CITY OF ALBUQUERQUE

January 15, 2021

Re: Jiffy Lube
9386 Coors Blvd NW
Traffic Circulation Layout
Engineer's/Architect's Stamp 1-8-21 (C13D024)

1 SITE PLAN
1"=20'

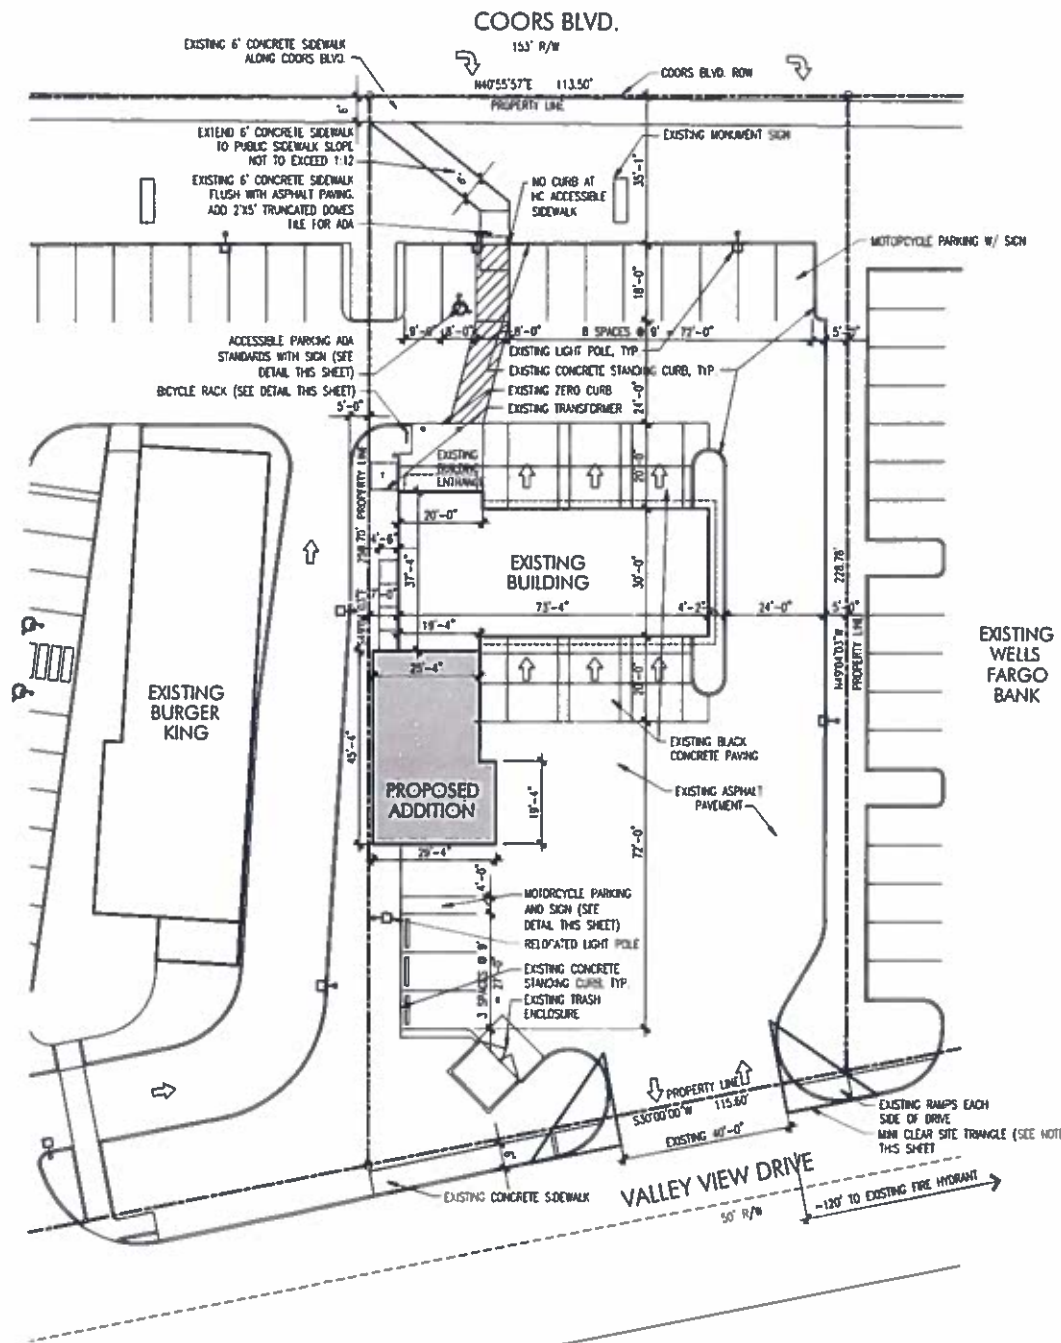
1. Please identify property lines.
2. Call out right of way location.
3. Call out existing width of sidewalk.
4. Work in the Right of Way requires DOT approval (Sidewalk)
5. Provide details of 6 foot ADA Ramp connecting sidewalk to ADA access aisle. (Existing concrete sidewalk.) Is this ADA compliant?
6. Call out entrance door for ADA access.
